Permit Reviews

Permit Number: **BCOM2603-0006**

Description: **Hispanic Snack Convention Bar**

Site Address: **161 S MCKINLEY ST**

LA COSECHA SNACKS
 161 S McKinley Street, Coats, NC 27521

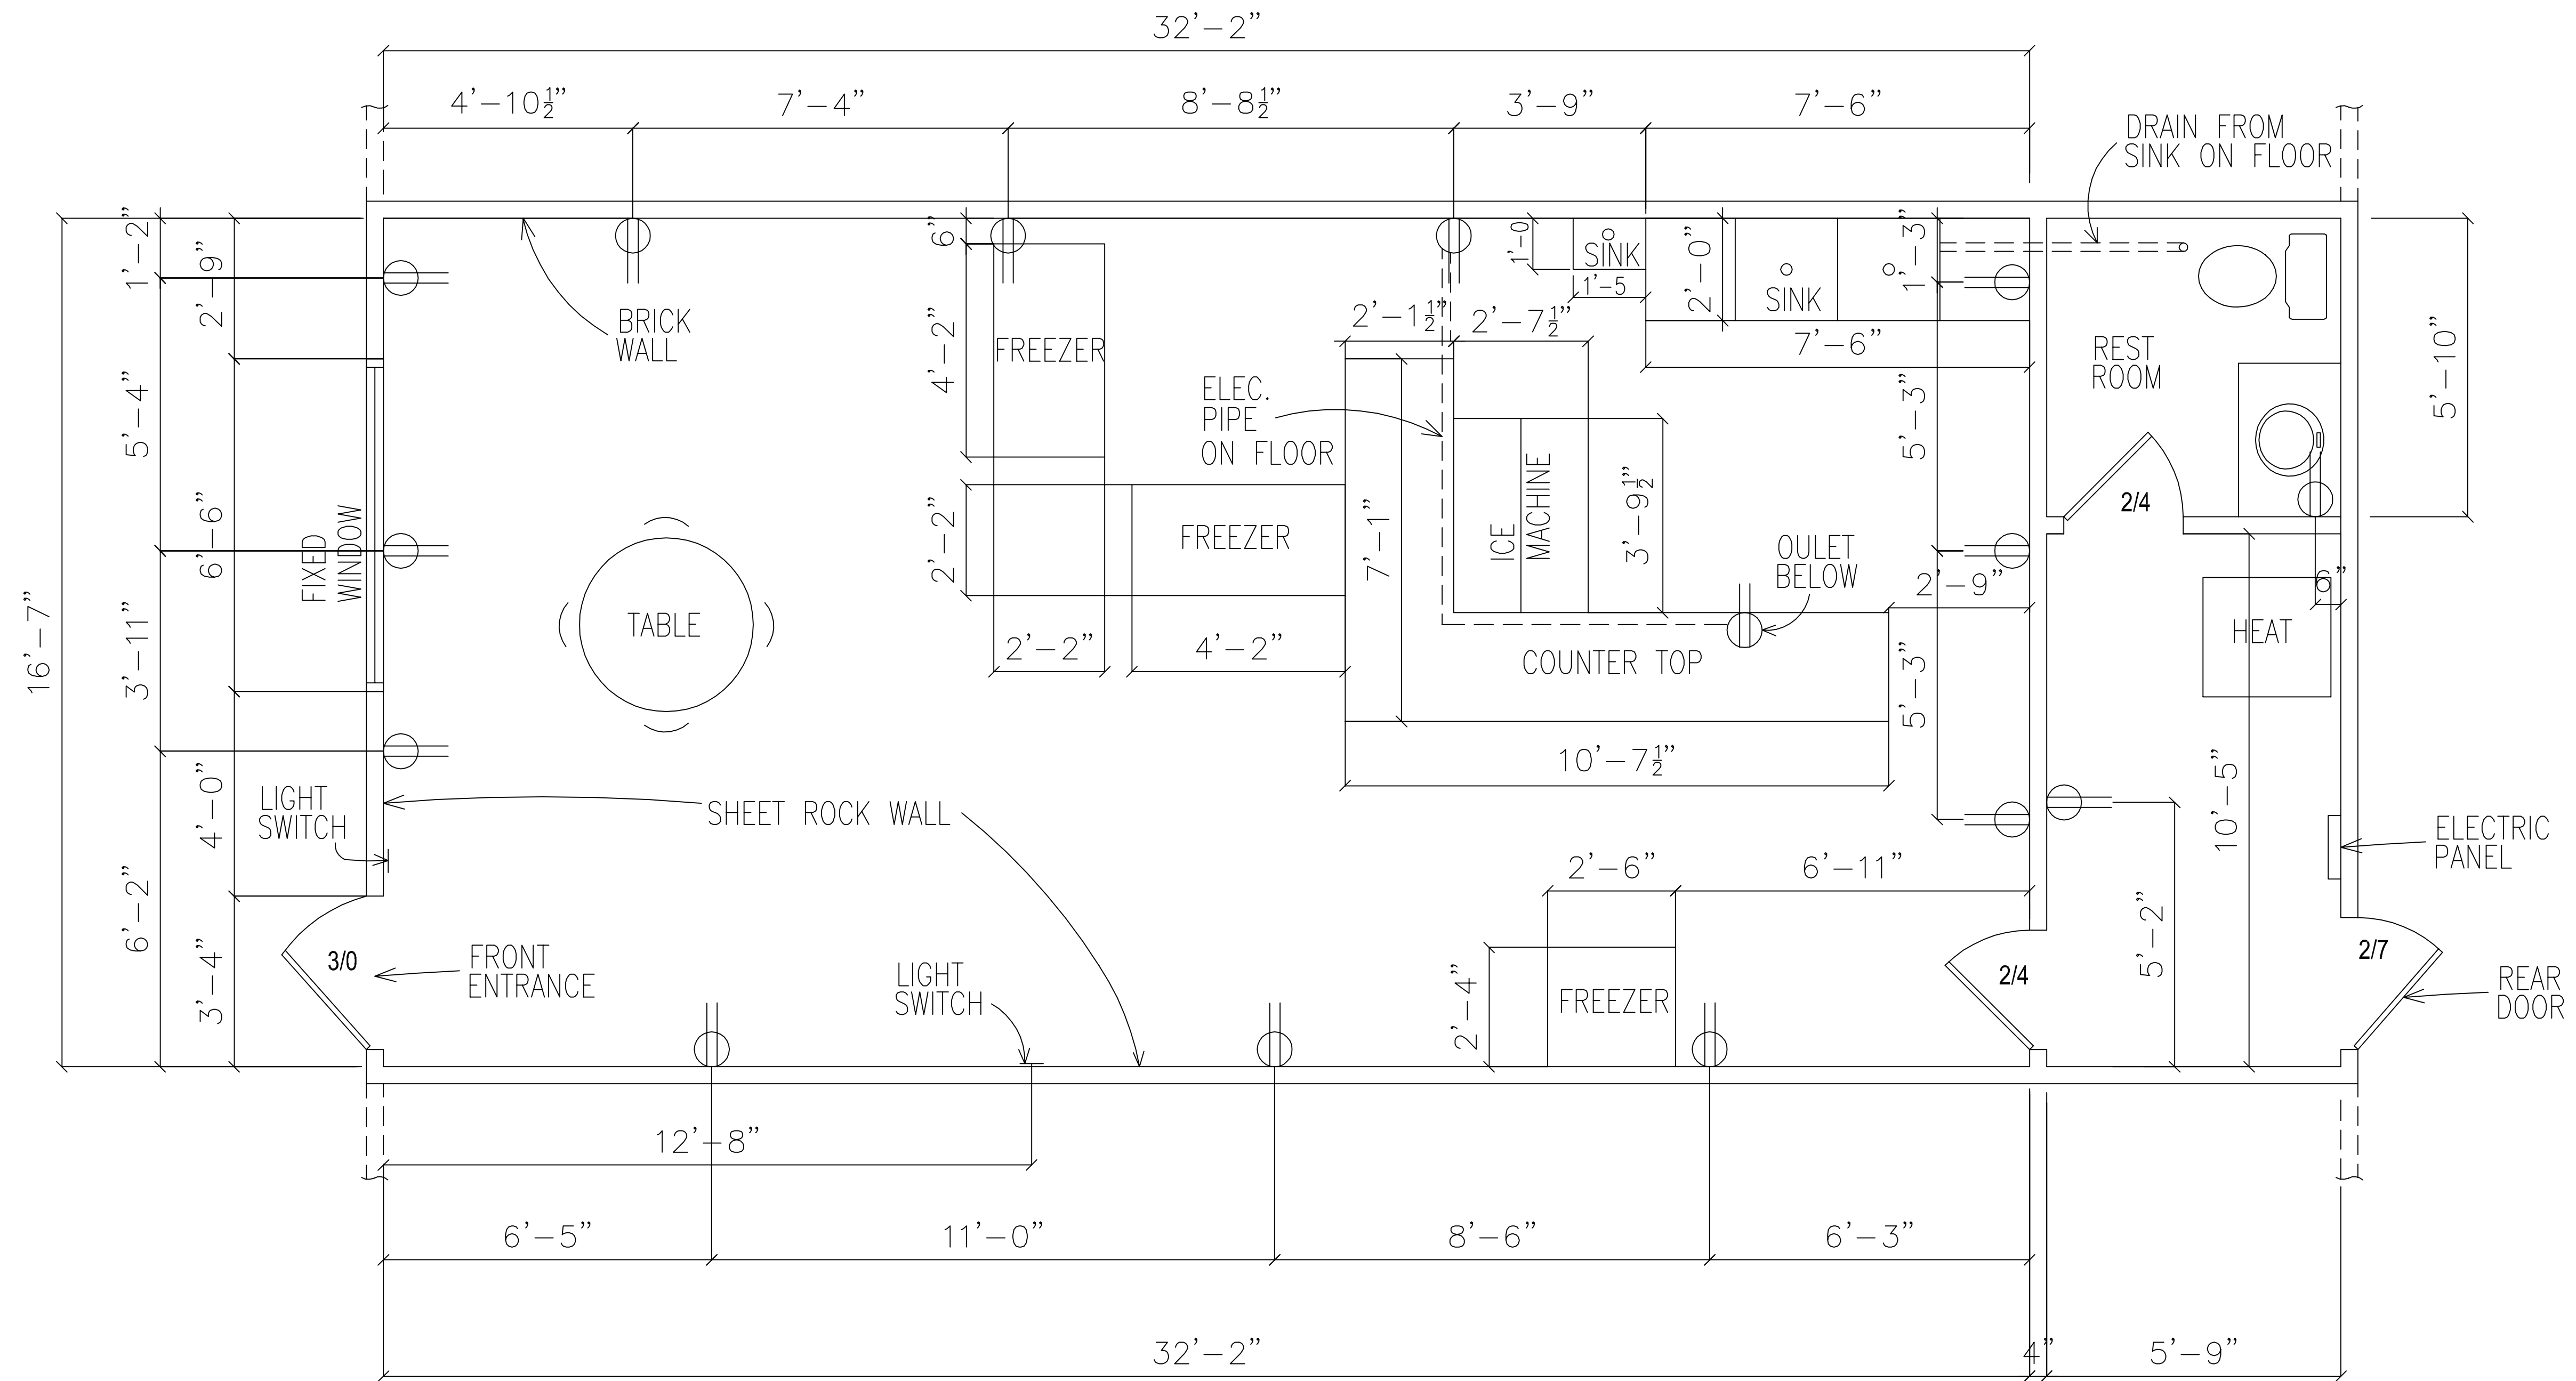
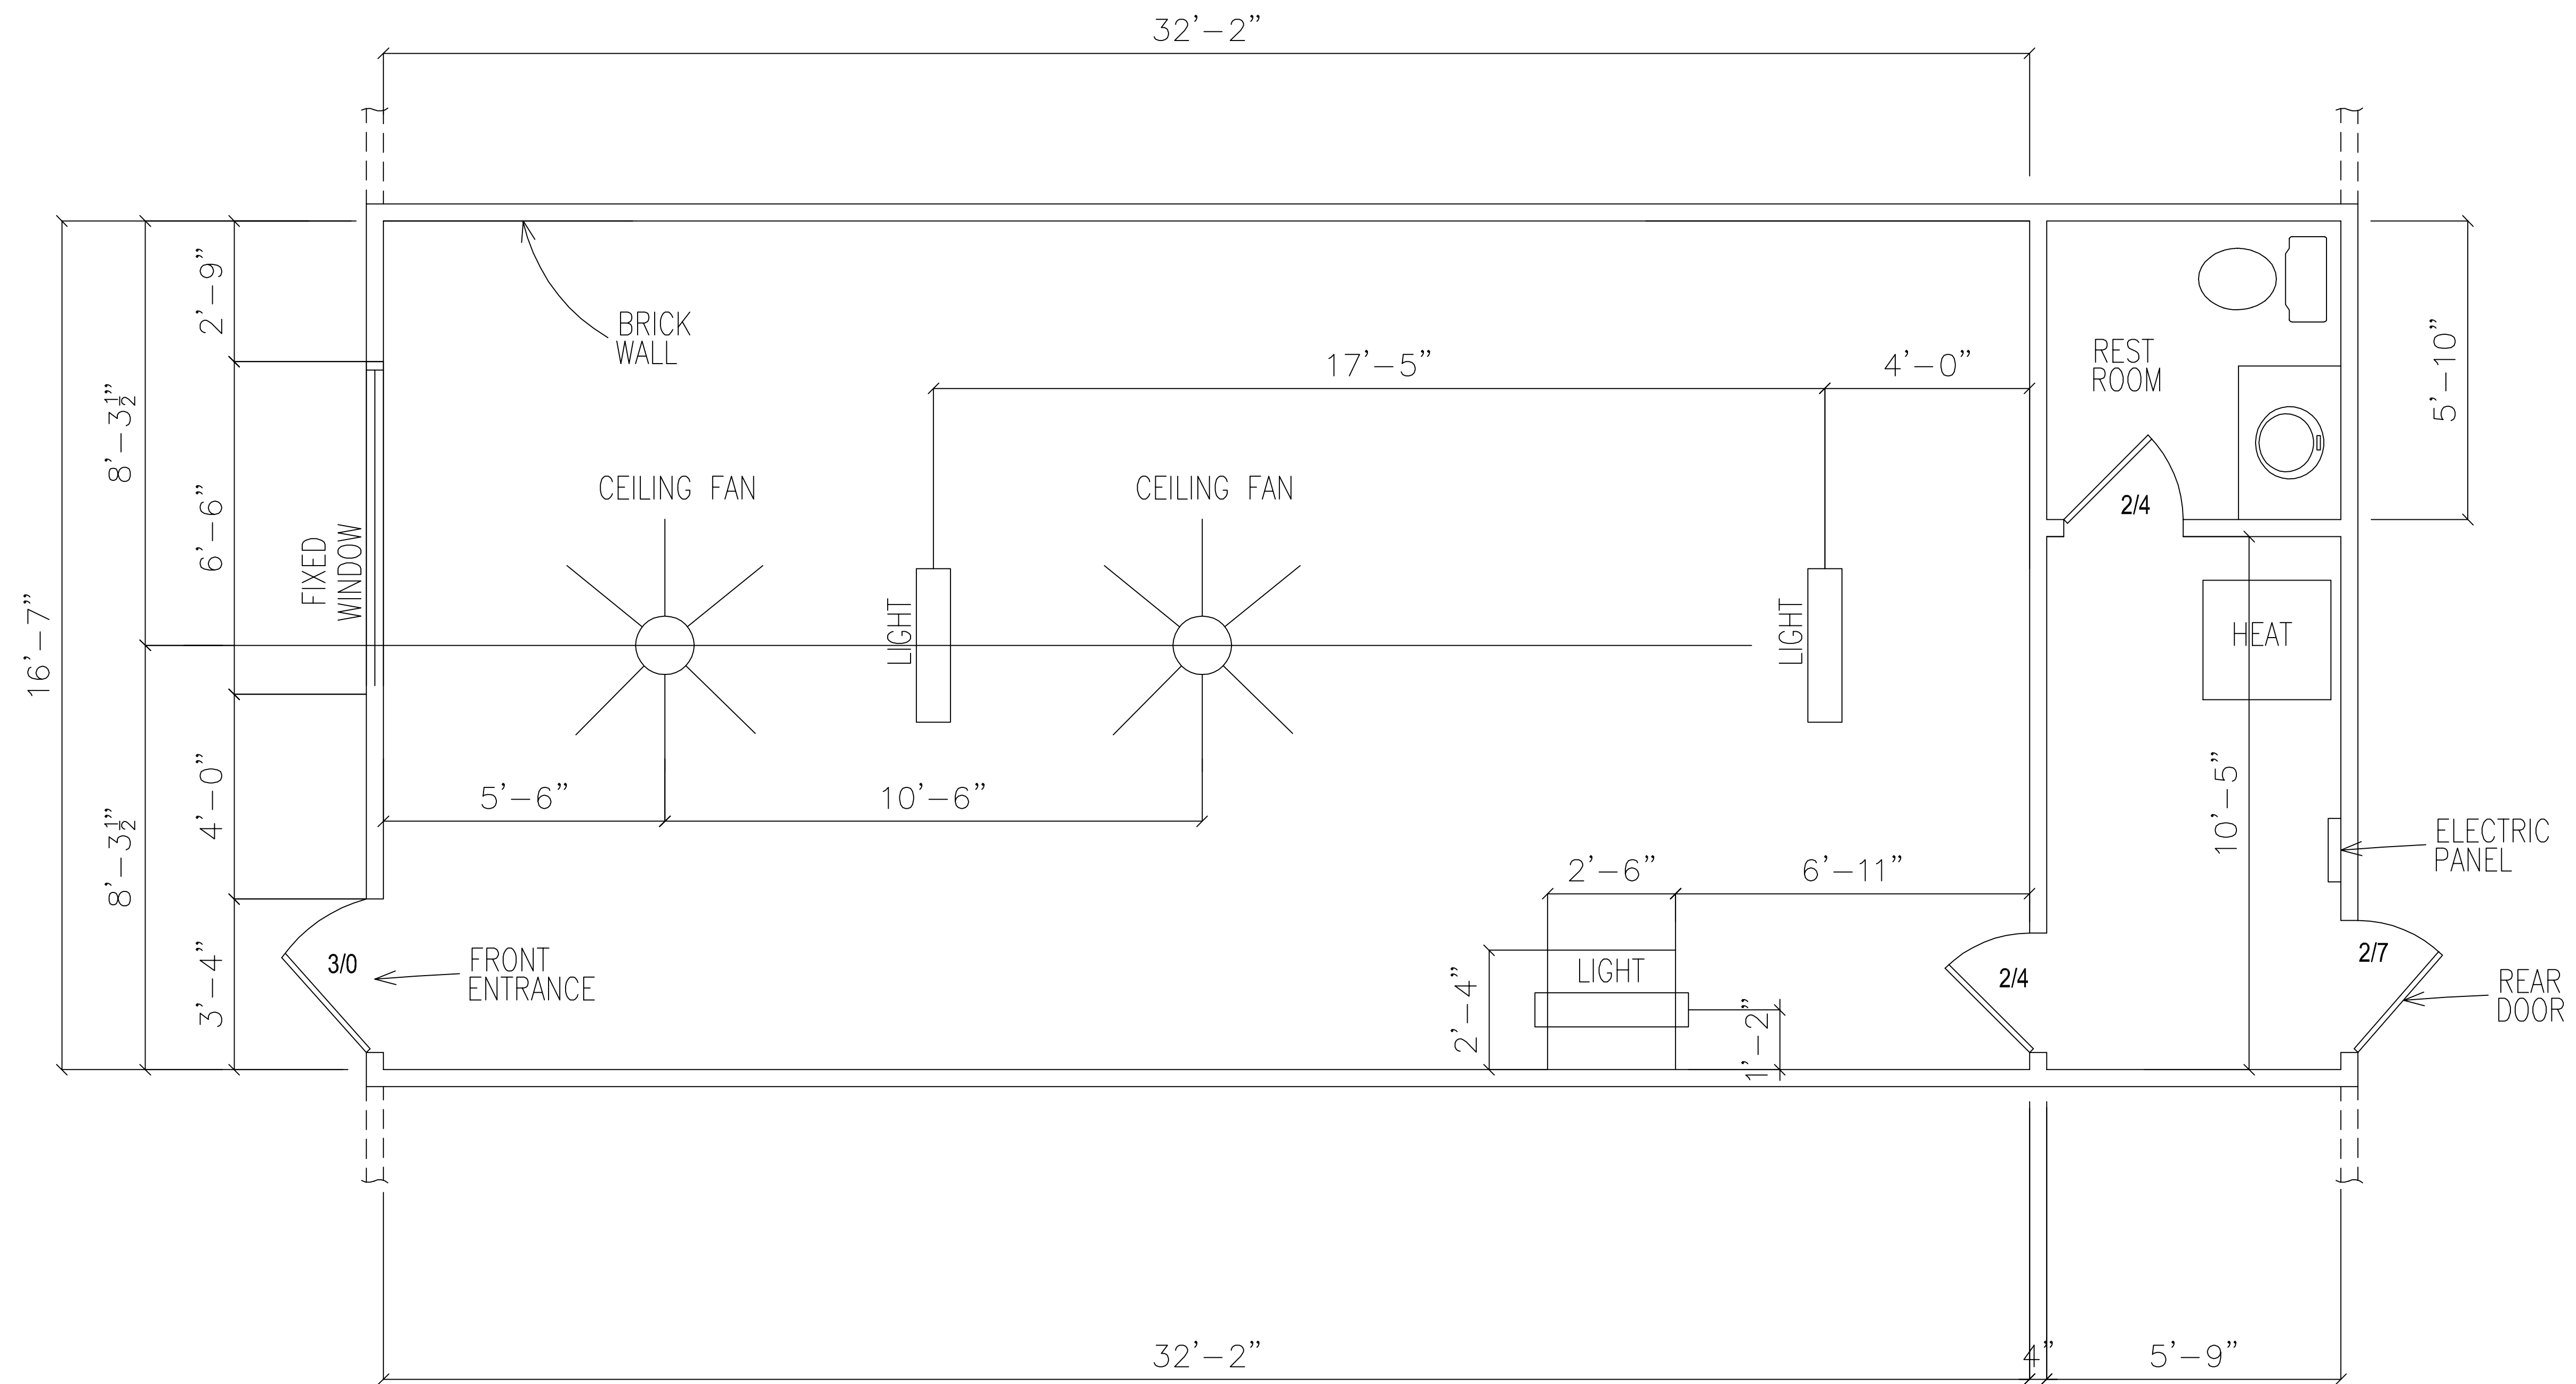
- Life safety plan, fire extinguishers, emergency and exit lighting.
- Cooking hood plans if any cooking or frying will be done.

- No cooking or frying will take place; fruit will be cleaned & cut up.
- Outside grease trap is required.

After reviewing our Oil and Grease Control Ordinance, for this restaurant to install something other than a 1,000-gallon interceptor, they must request a variance. The requirements for the request must be in accordance with Part C, 7, d on page 4 of the Ordinance. This request must be in writing and received before I can approve them for a smaller grease interceptor.

1. You install a minimum of a 50 GPM poly grease trap on the 3-compartment sink. All compartments will be plumbed to the trap. If additional kitchen or prep sinks are installed, you will be required to install additional traps.

3/25/2026	4/1/2026	4/9/2026	COMMERCIAL BUILDING REVIEW	Brad Sutton	DISAPPROVED	
<p>Notes:</p> <p>Need a scaled plan Need food details. Cooking? Prepackaged? If cooking, provide hood and cooking equipment details</p>						
4/1/2026	4/20/2026	4/21/2026	COMMERCIAL BUILDING REVIEW	Brad Sutton	DISAPPROVED	
<p>Notes:</p> <p>Customer submitted new life safety plan/site plan. No cooking or frying will take place; fruit will be cleaned & cut up. Cant approve until I know what requirements EH will have for equipment</p>						
5/19/2026	6/2/2026	6/2/2026	COMMERCIAL BUILDING REVIEW	Brad Sutton	DISAPPROVED	
<p>Notes:</p> <p>Waiting for EH and HRW req. Equipment specs, etc</p>						
6/2/2026		6/16/2026	COMMERCIAL BUILDING REVIEW	Building Bucket		
<p>Notes:</p> <p>Menu changed--no longer going through H&S. Customer will be going through NCDA for health regulations.</p>

4/7/2026	4/15/2026	4/21/2026	FIRE MARSHAL	Fire Bucket	APPROVED	See attached letter
<p>Notes:</p> <p>-Customer confirmed that exit signs & lighting are above exits on new life safety plan/site plan. Fire extinguisher is shown on new plan. -No cooking or frying will take place; fruit will be cleaned & cut up.</p> <p>See attached letter.</p>						
4/15/2026	4/15/2026	4/15/2026	HEALTH AND SANITATION	Cynthia Pierce	DISAPPROVED	
<p>Notes:</p> <p>Application incomplete, site plan not adequate or drawn to scale, need equipment spec sheets, need food process sheets. Emailed sent to applicant requesting information, application sent back via email.</p>						
Review Group: 2ND PLAN REVIEW						
4/28/2026	4/30/2026	5/12/2026	HEALTH AND SANITATION	Cynthia Pierce	DISAPPROVED	
<p>Notes:</p> <p>I spoke with Amelia on 4-30. Discussed the following: Newly submitted information is not adequate and additional information is needed. Missing completed food service application. Applicant turned in 4 pages. Turn in entire FS application completed. Site plan drawn to scale missing. Equipment specification sheets missing or not adequate. Recommended applicant hire a restaurant consultant to help her with the plan review submittal process.</p>
